From: Karl Roberts <Karl.Roberts@arun.gov.uk>
Sent: 20 December 2019 10:06
To: Planning.Responses <Planning.Responses@arun.gov.uk>
Subject: FW: A/100/19/PL - Arundel Acre - response to Highways England

Subject: RE: A/100/19/PL - Arundel Acre - response to Highways England

Subject: A/100/19/PL - Arundel Acre - response to Highways England

1711056-SK01

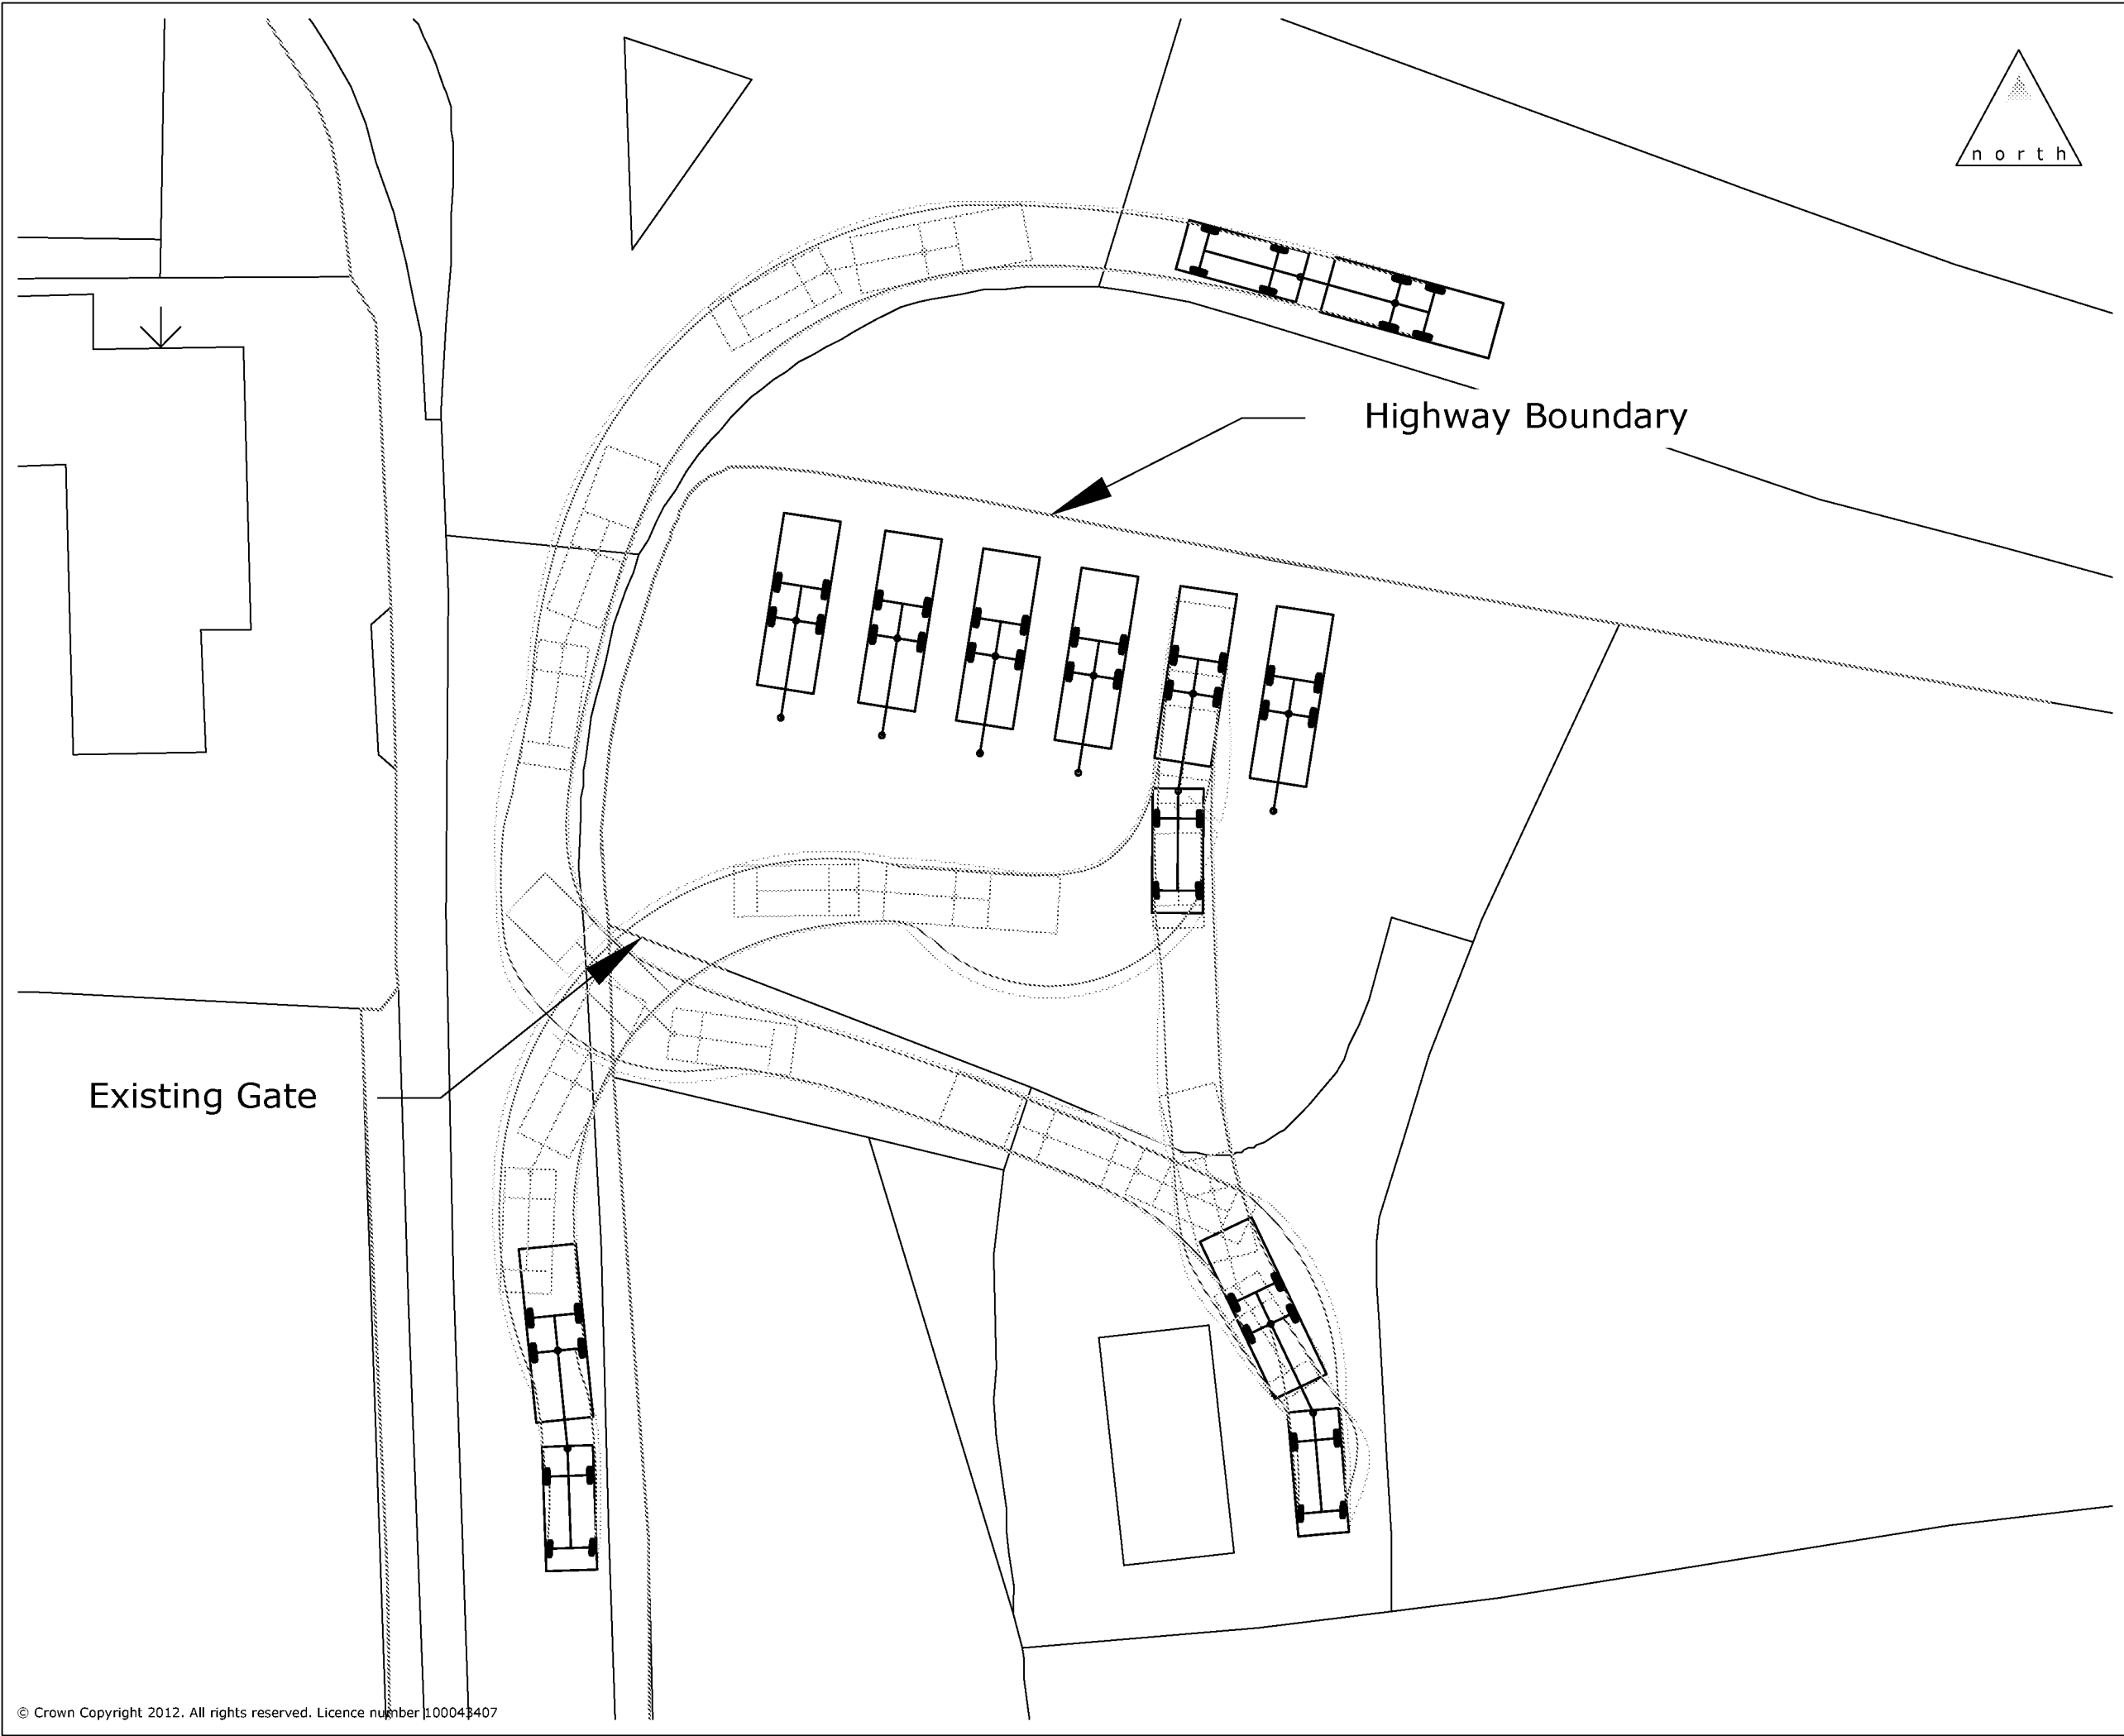
You have requested that the visibility splay be based on DMRB and not on MfS – You will note that, as during the assessment of the planning application, the planning Inspectorate accepted on Paragraph 8 of the Appeal Decision that the northern visibility splay, shown on **Appendix D - Drawing SK01A** achieving 21.2m **“now meets the requisite standard set out in Manual for Streets (MfS)”**. Such approach is consistent with the lack of objection received from Highways England for the previous proposal and therefore we consider it is unreasonable to request this visibility splay now to be based on DMRB.

Appendix D – Drawing No: JNY10317/02

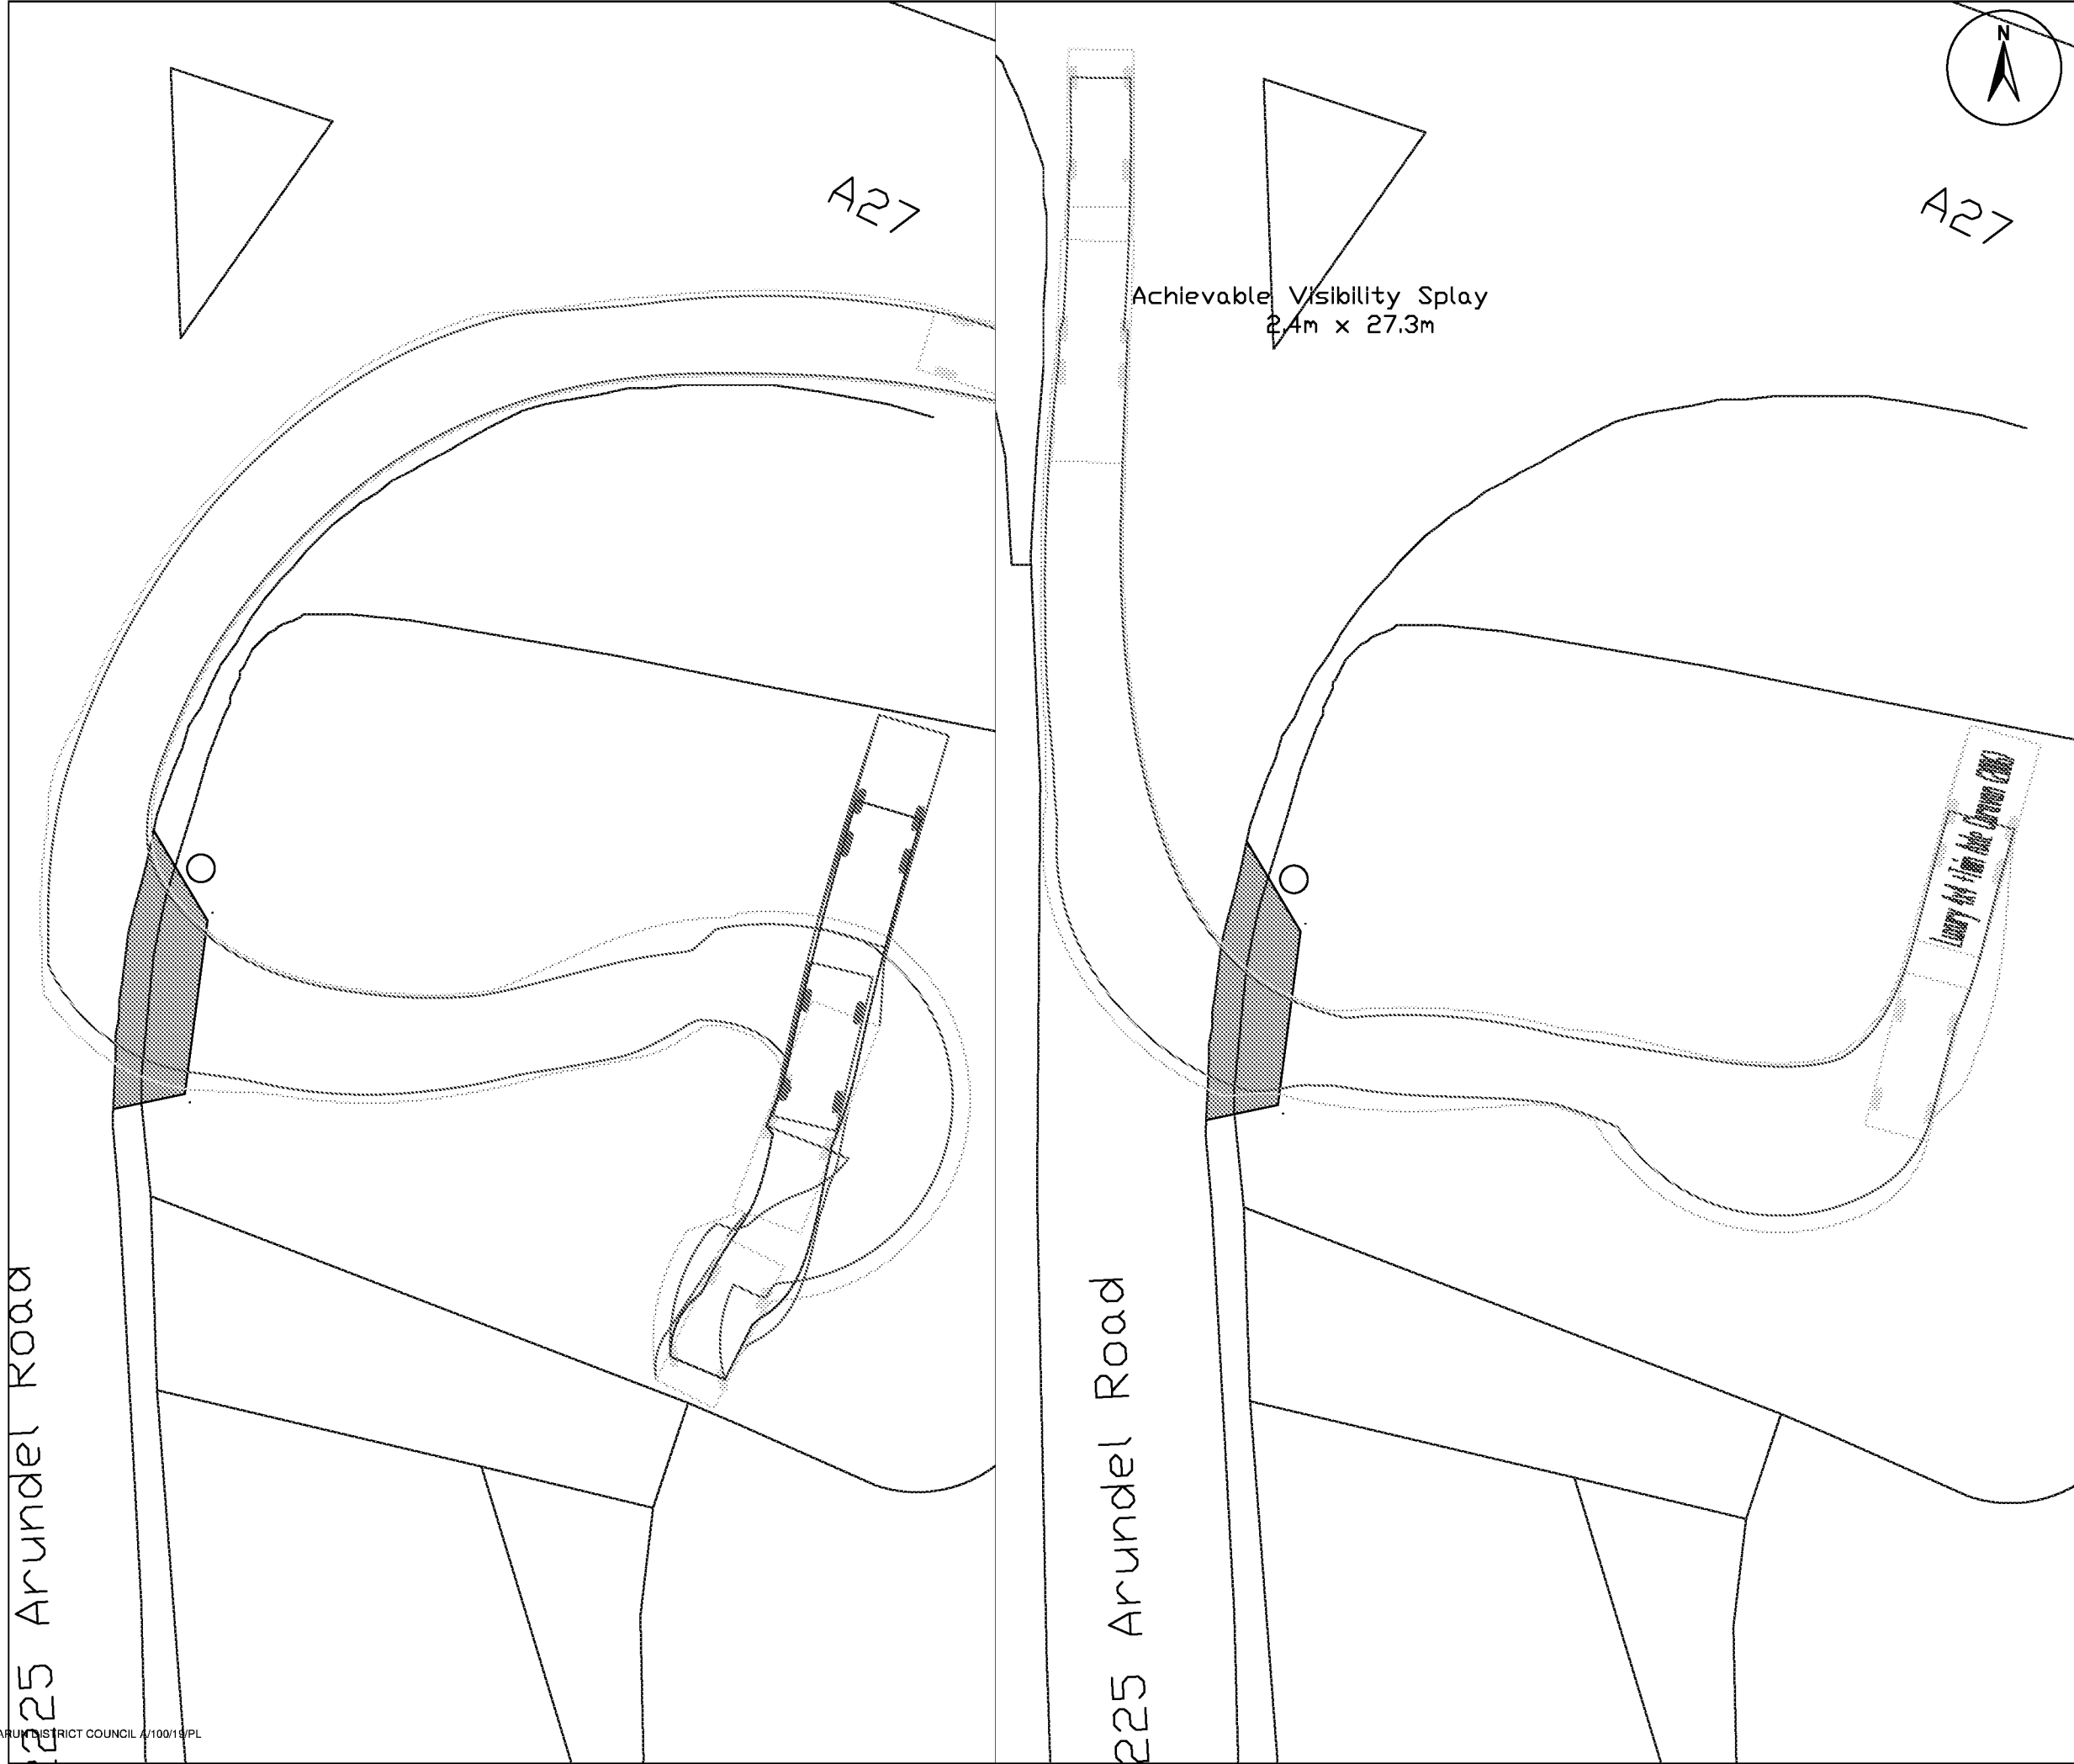
We also attach an updated vehicle tracking diagram (Drawing No. JNY10317/02) demonstrating that vehicles will be capable of entering and leave the site on forward gear.
